Immingham Green Energy Terminal

10.1 Proposed Change Notification Report

March 2024

Document Reference: TR030008/EXAM/10.1

LEGEND

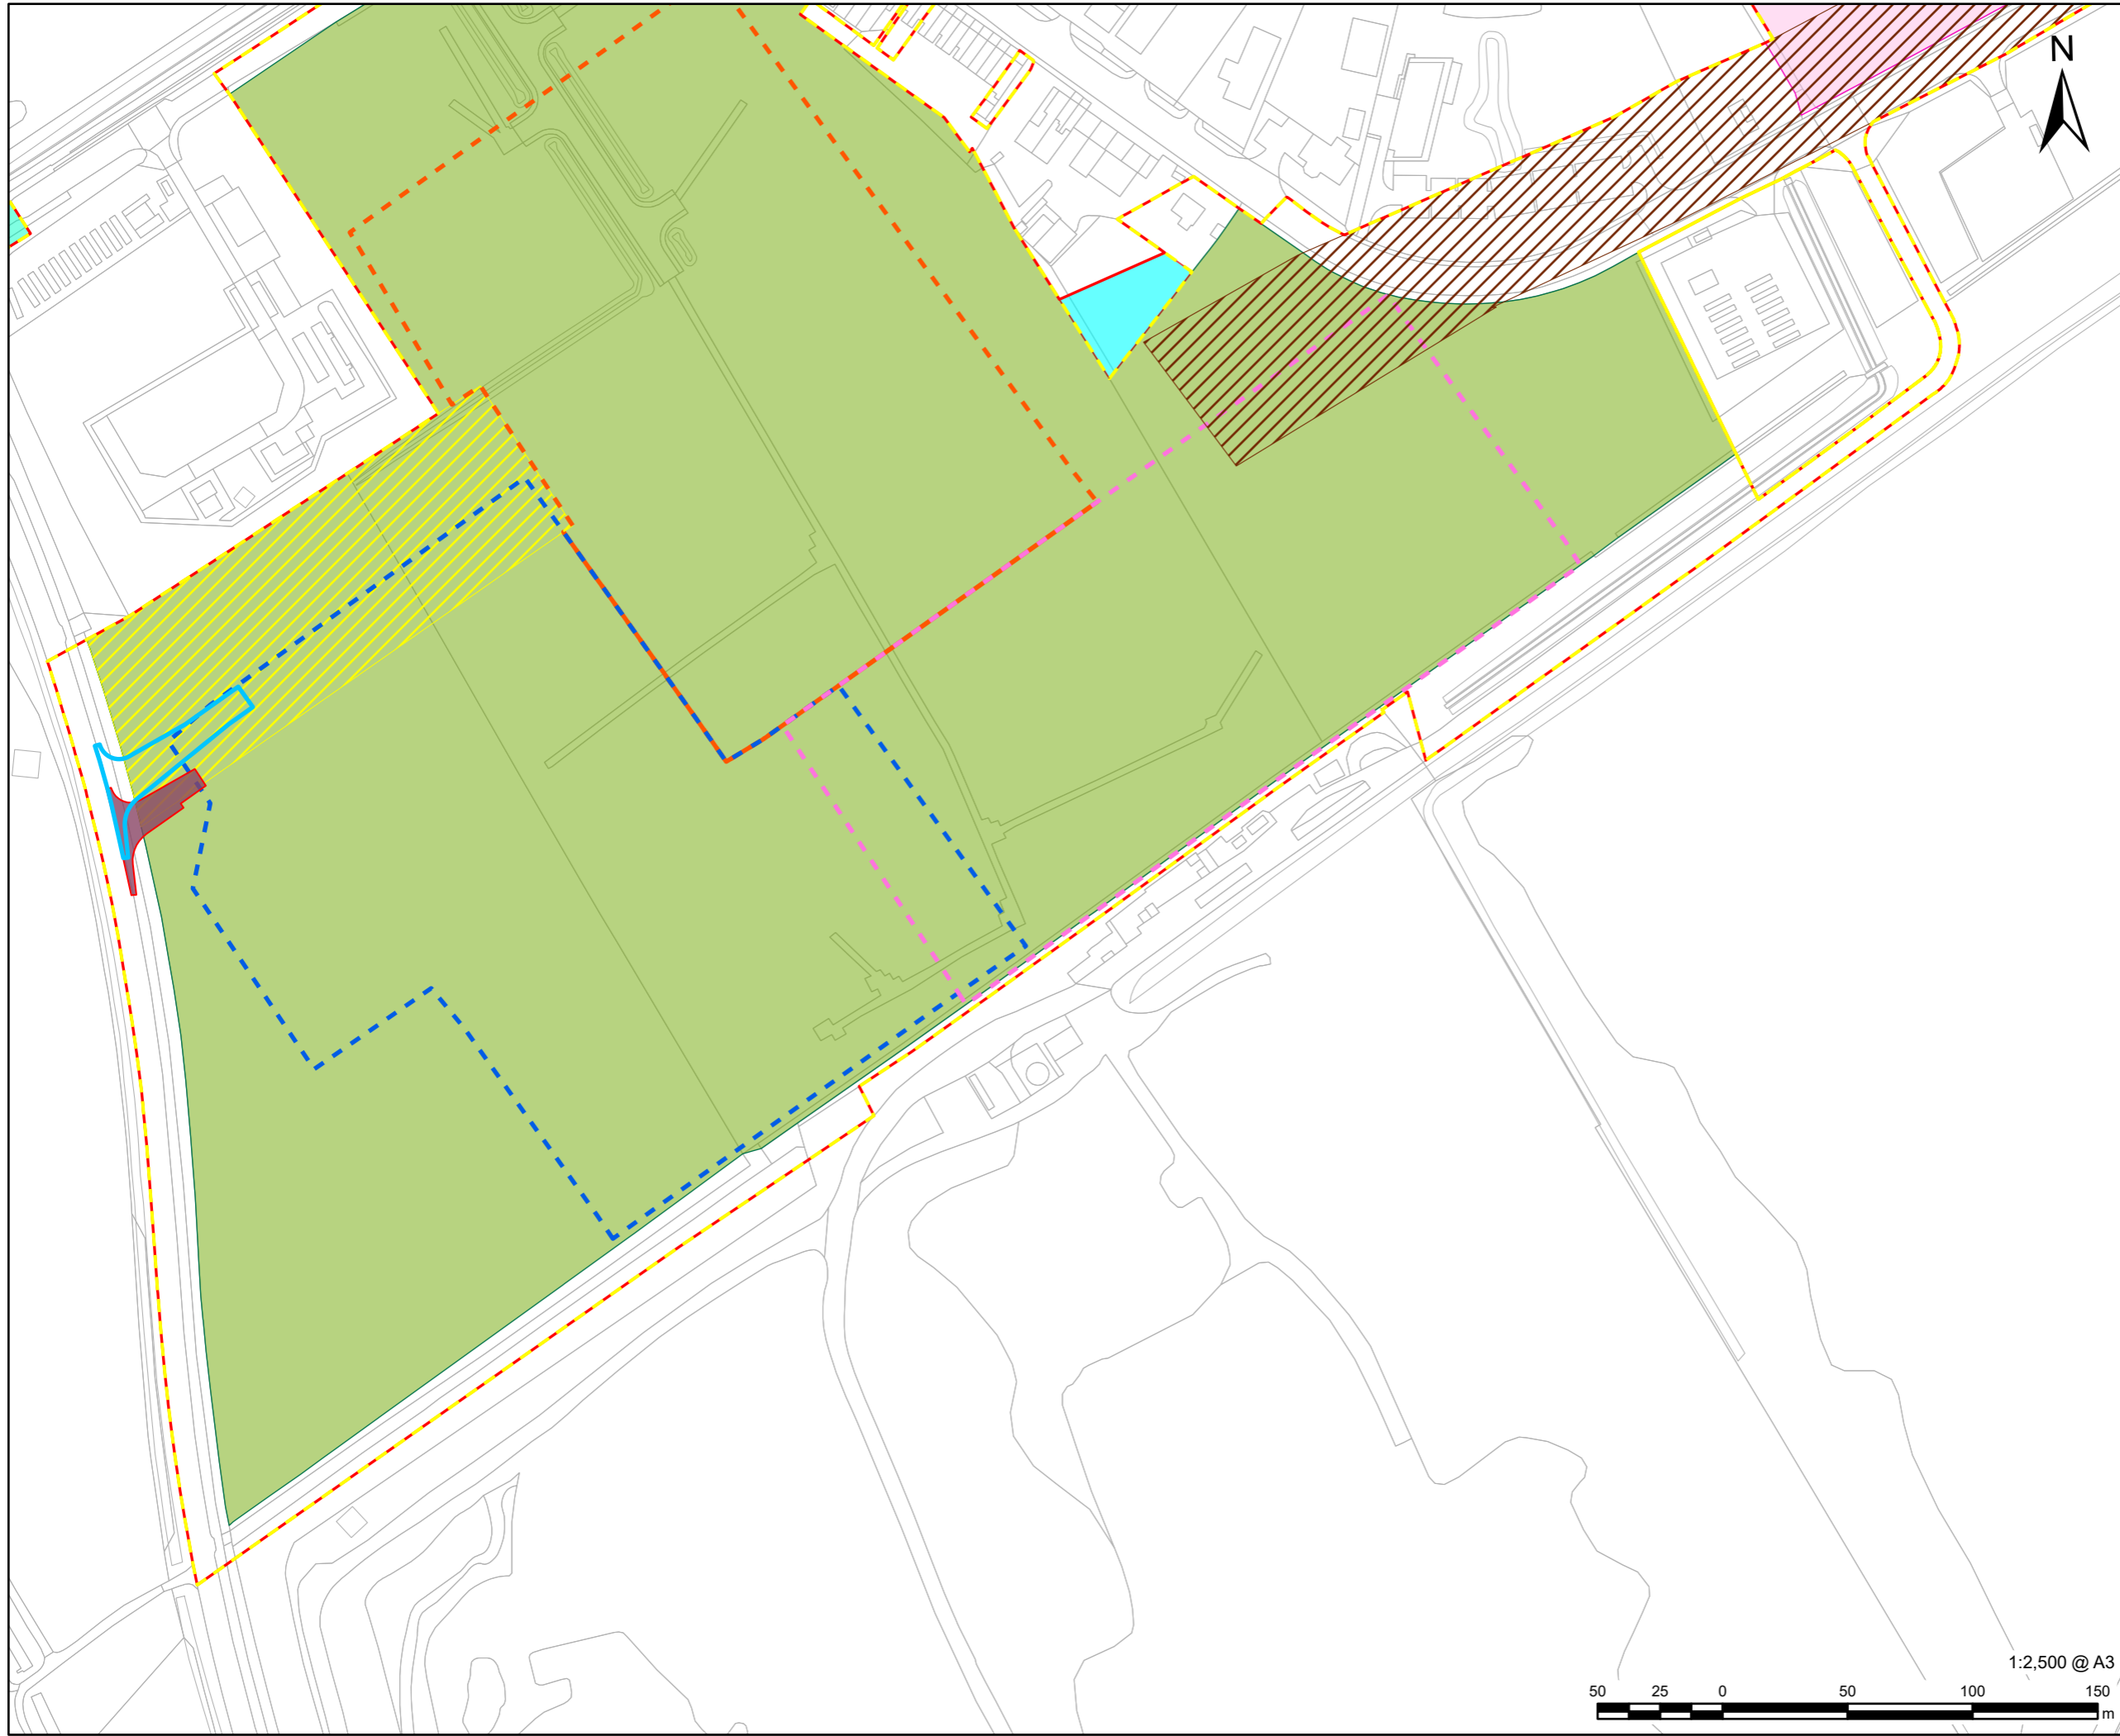
- 2.4.1 Proposed Change 3 comprises minor changes to the northern access from the A1173 to Work No. 7 (marked "AB" on the Street Works and Accesses Plan [APP-016] and referred to as "Access AB" below) and amendment of the red line boundary (Order Limits) at the eastern edge of Work No. 7 to include additional land for temporary construction purposes.

- 2.4.3 Proposed Change 3 requires the extension of the red line boundary to include a small area of additional land to the east of Work No. 7. The inclusion of this land is for the purposes of construction, and therefore powers of temporary possession are sought in respect of this land, rather than powers of compulsory acquisition. As a result, the CA Regulations are not triggered by this Proposed Change 3. The outline Construction Traffic Management Plan will be updated to reflect this change.

- 2.4.4 Proposed Change 3 also includes minor changes to Access AB. As a result of the slight shift of the likely layout of the hydrogen production facility, Access AB needs to be adjusted by approximately 10-15 metres to the north west.

2.5.1 Proposed Change 4 consists of the addition of visual detail to Work No. 1a in the Works Plans **[AS-002]** to include the walkways linking the jetty head to the mooring dolphins as shown in Work No. 1a. These walkways are already described at Paragraph 1(a)(i) of Schedule 1 (Authorised Project) and at Paragraph 3(2)(a)(ii) of Schedule 3 (Deemed Marine Licence) of the dDCO **[REP1-016]**.

2.5.2 The visual addition of the walkways in the Works Plans **[AS-002]** is shown indicatively in Figure 5 below and on Sheet 1 of 2 in Appendix 3.
